CITY OF ALBUQUERQUE

January 29, 2024

**RE: U-Haul
8200 Jefferson Street NE
Conceptual Grading and Drainage Plan
Engineer's Stamp Date: No Stamp Date
Hydrology File: C17D146**

GRADING AND DRAINAGE PLAN

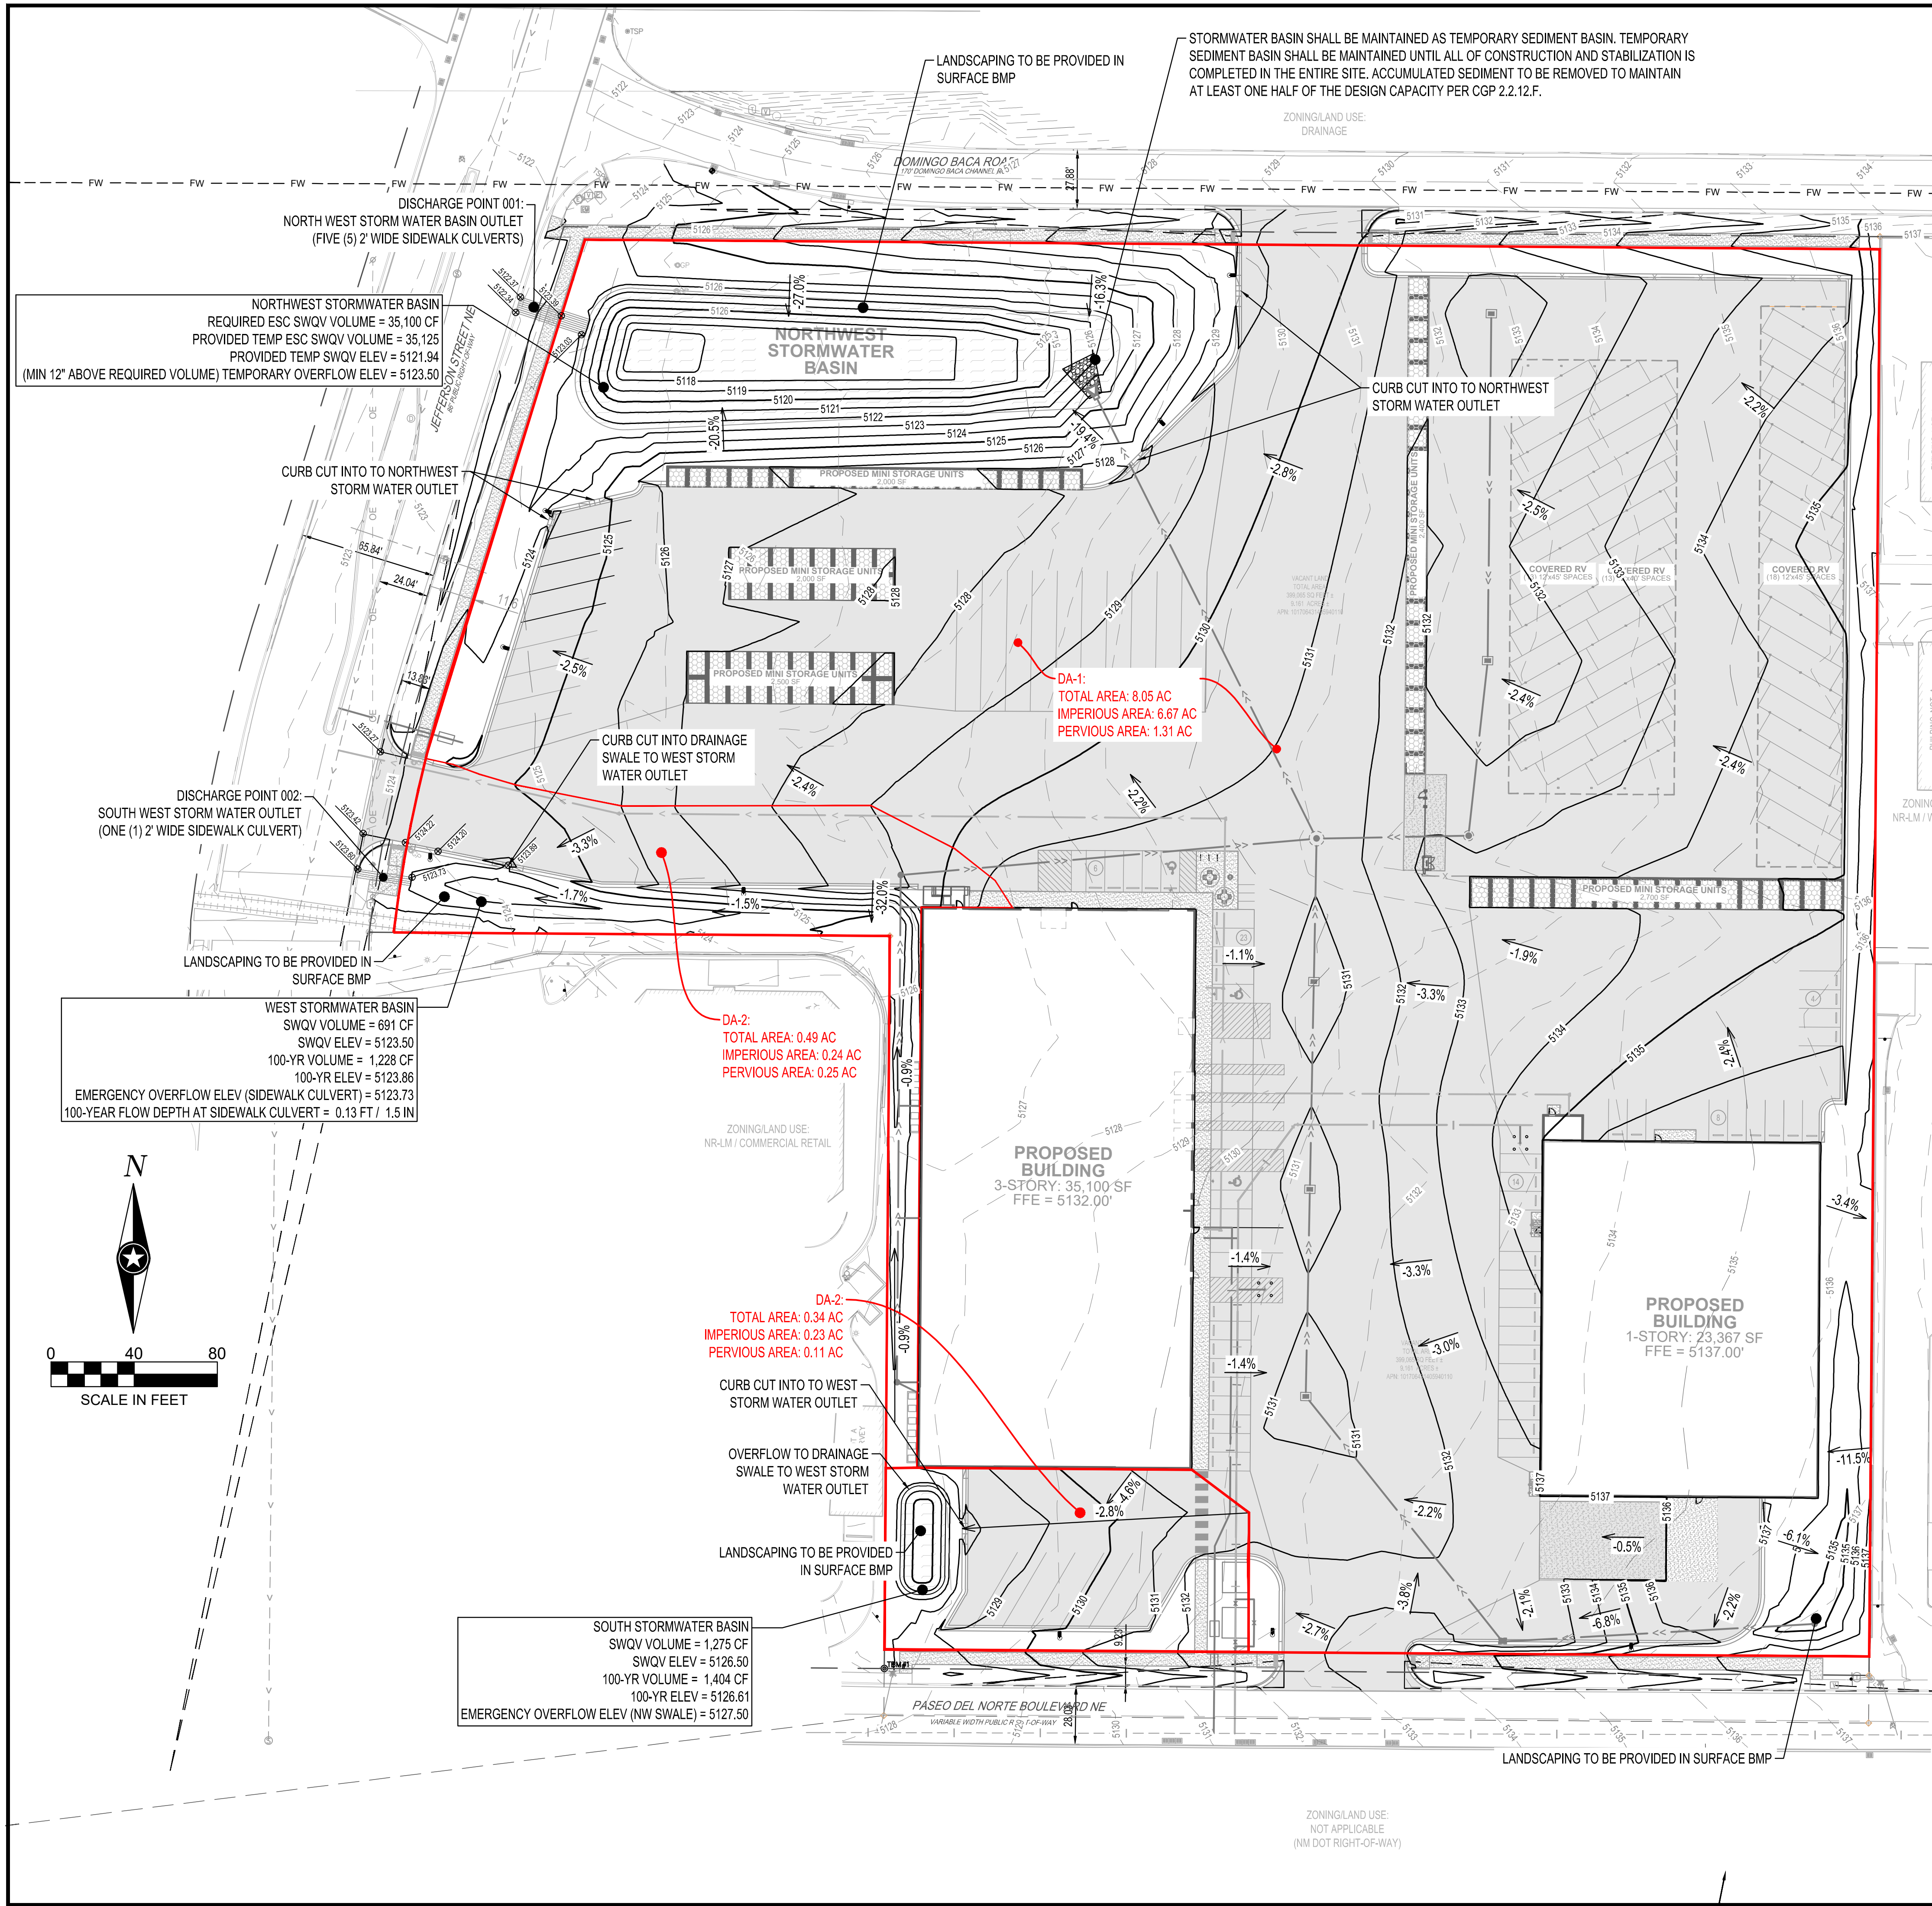
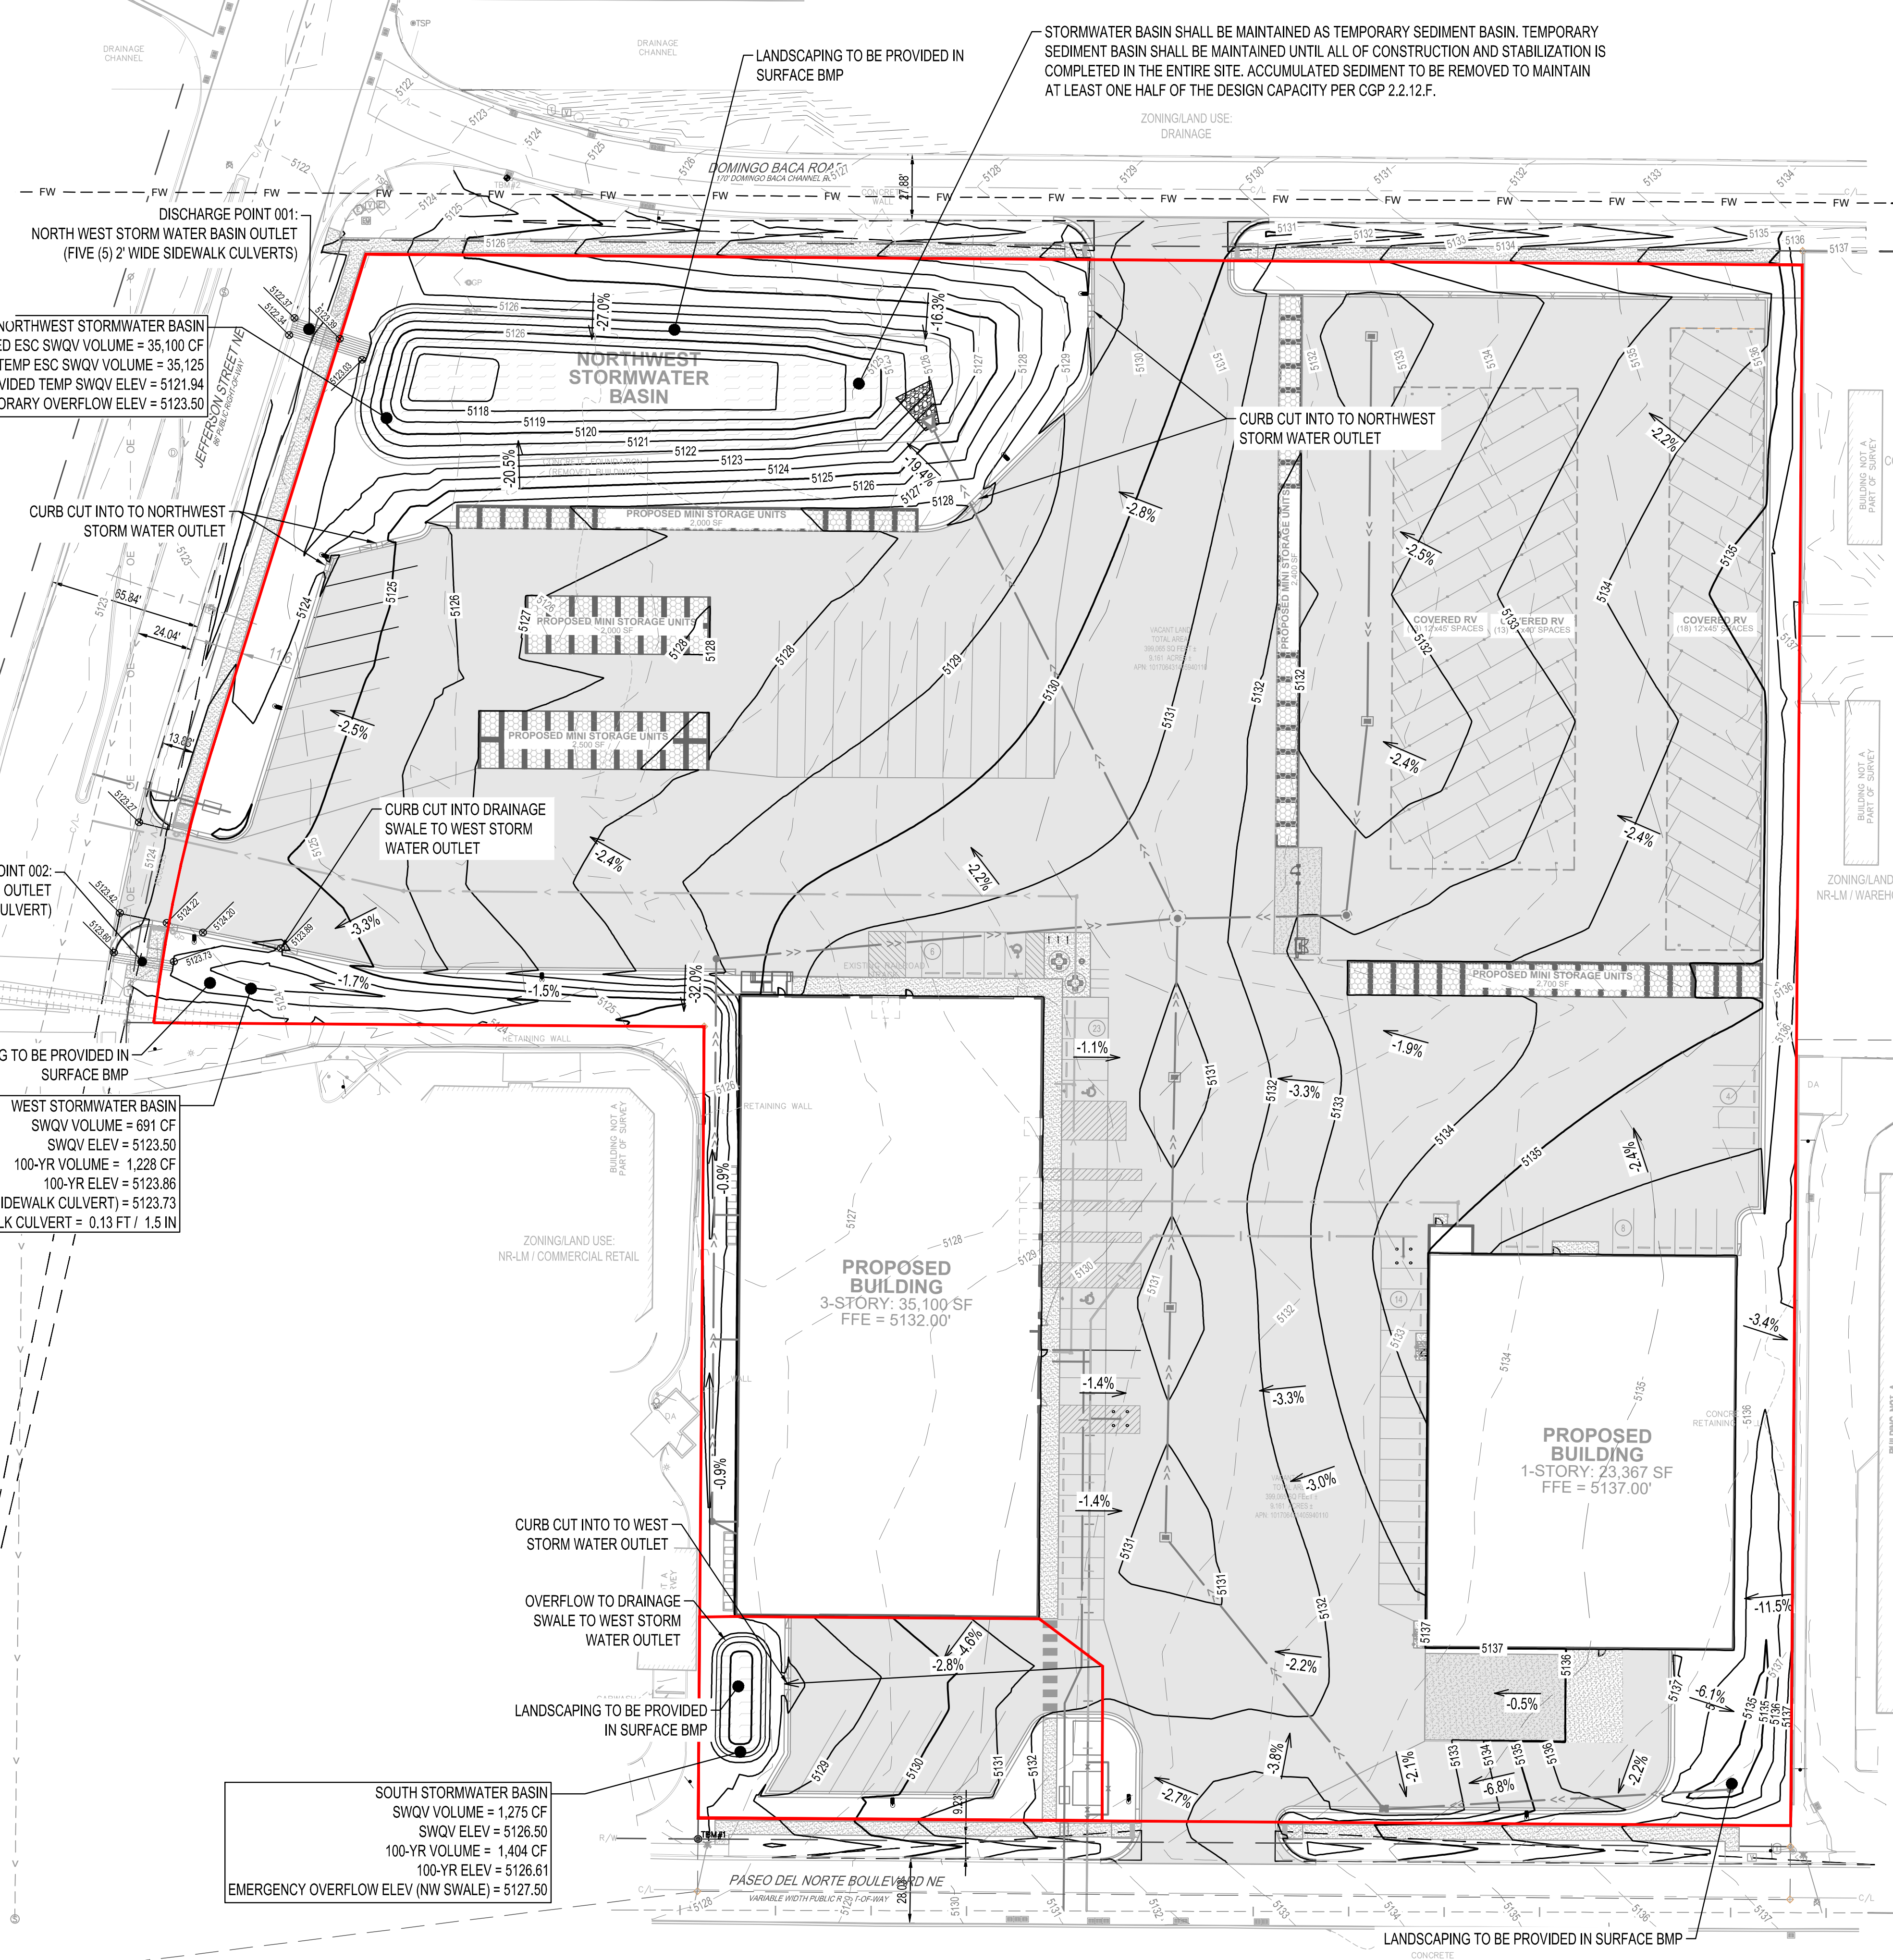
1. Per the DPM, the following must be on the Grading Plan. Please note the Grading Plan must be a stand-alone construction document.
 - a. Please provide a licensed New Mexico civil engineer's stamp with a signature and date.

- b. Please provide a Vicinity Map. Typically, this is the Zone Atlas. This can be downloaded in pdf format from the City of Albuquerque's website.
 - c. Please provide the Benchmark information (location, description and elevation) for the survey contour information provided.

- d. Please provide the FIRM Map and flood plain note with effective date.
 - e. Please provide a legal Description of the property.
2. Please use the procedure for 40 acre and smaller basins as outlined in Development Process Manual (DPM) Article 6-2(a). Please provide both the existing conditions and proposed conditions for the 100 year-6 hour storm event.

associated water surface elevation and the 100-year water surface elevation. Landscaping of surface BMPs is also required to be noted on the Grading and Drainage Plan.

4. Please show the existing railroad spur that goes through the property along with the railroad easement.

5. The Site Plan shows a proposed building and site work over the existing railroad spur and railroad easement noted in Comment #4. Please provide a notarized letter from the owner of the existing rail road easement stating that construction can be done on their easement.

- Since there is an existing railroad spur through the site as indicated in Comment #4, the site will have two separate drainage discharge points. The southern portion drains to a Stormwater Quality Pond with an emergency spillway as a sidewalk culvert to Paseo de Norte Access Rd.

The northern portion drains to a Stormwater Quality Pond with an emergency spillway as a sidewalk culvert to Domingo Baca Rd.

7. Please provide the weir calculations, per DPM Article 6-16(A), for the curb cuts and sidewalk culverts. A coefficient of 2.7 is typically used for the weir equation $Q = CLH^{2/3}$.
8. A waterblock, 0.87' high, per COA Paving Detail No. 2426, is required at the driveway entrance.
9. Please note Paseo del Norte Access Road is within NMDOT jurisdiction. Since this project runoff goes into the New Mexico Department of Transportation's (NMDOT) Right of Way, written concurrence must be obtained from NMDOT D3 Drainage that this project can proceed. Please contact Tim Trujillo P.E (TimothyR.Trujillo@state.nm.us or 505-373-4987).
10. Add a note on the Grading Plan, "Prior to any work within the New Mexico Department of Transportation (NMDOT) Right-of-Way, an NMDOT permit will be required." Provide a copy of the issued permit prior to requesting Certificate of Occupancy.
